From: Dawn Appleton [REDACTED]
Sent: 22 November 2017 16:10
To: Anita Gardner
Subject: RE: EP/138/17/PL - 3 Dwellings and relocation of staircase - Land rear of Beechlands Cottages, Beechlands Close, East Preston

From: Anita Gardner [REDACTED]
Sent: 01 November 2017 11:38
To: Dawn Appleton
Subject: EP/138/17/PL - 3 Dwellings and relocation of staircase - Land rear of Beechlands Cottages, Beechlands Close, East Preston

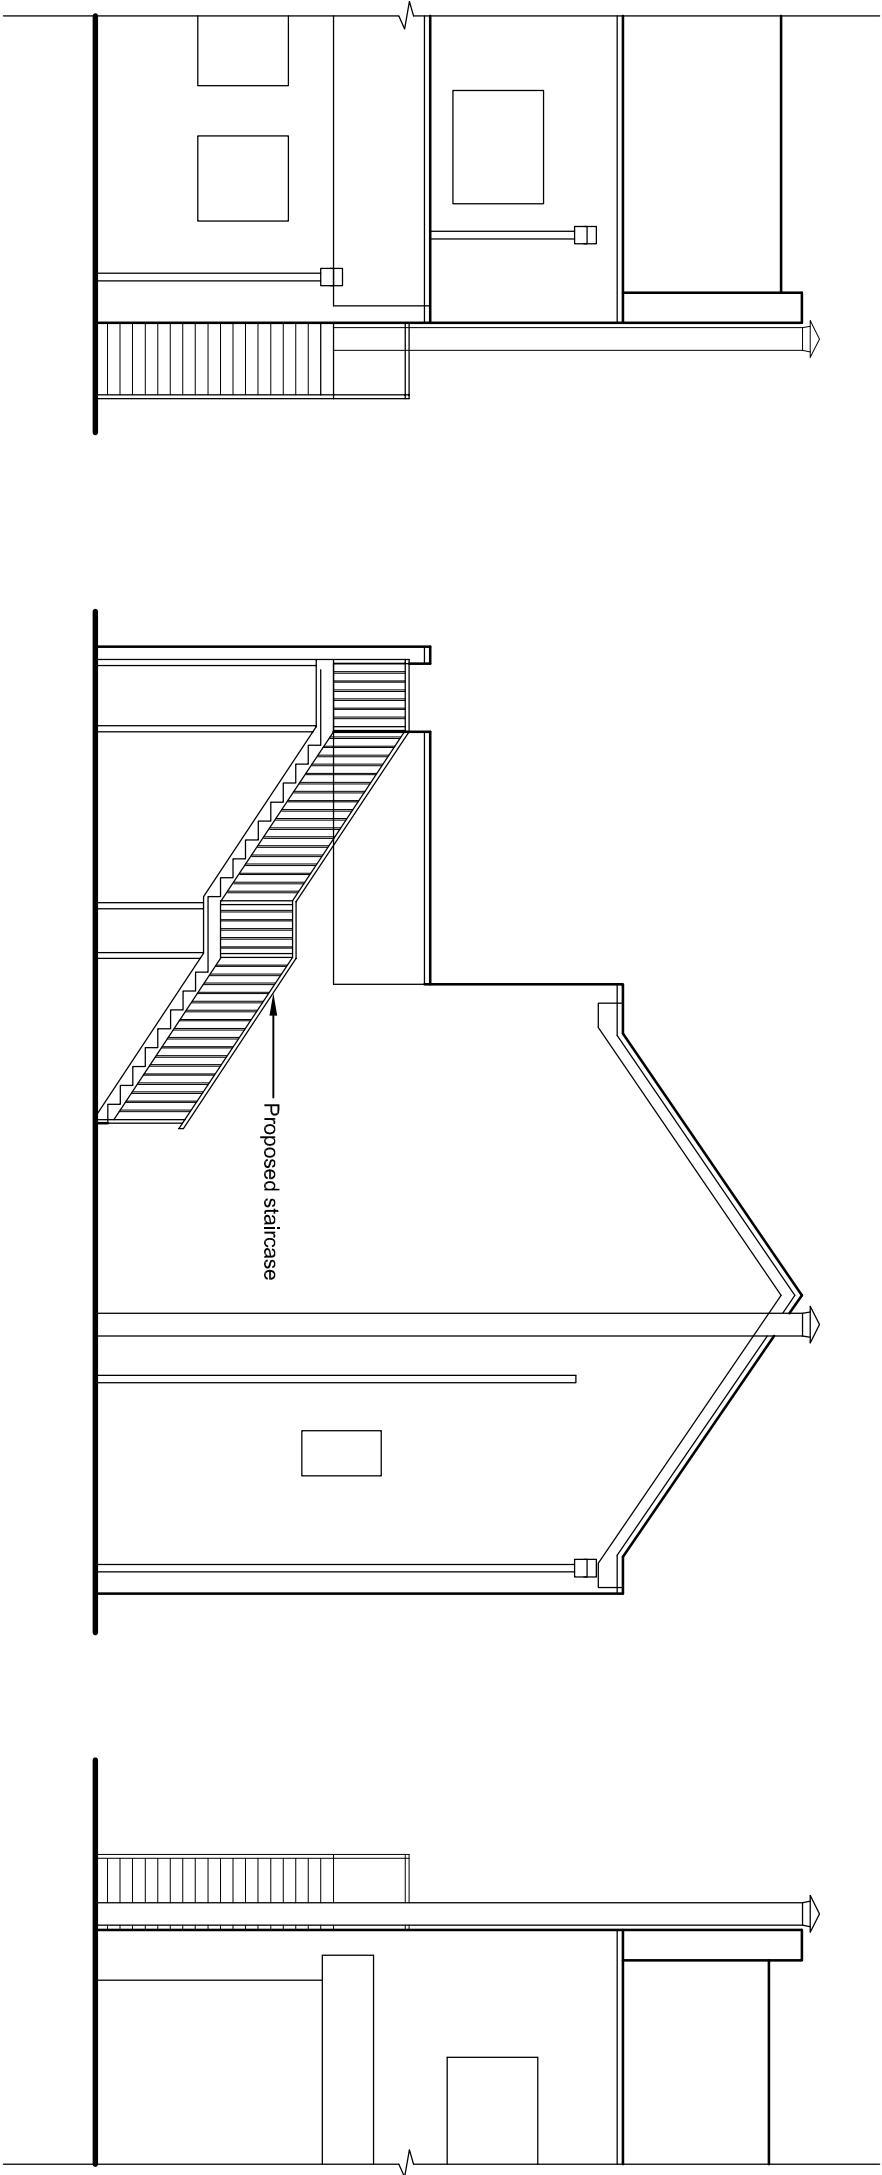
I have recently carried out my site visit for the above application. It is not clear from the submitted details where the proposed staircase to the flats is being located from and there are no elevation details of this part of the proposal. I also note that there is no existing site or block plan.

I am pleased to attach the plans you have requested. Please let me know if you require anything further.
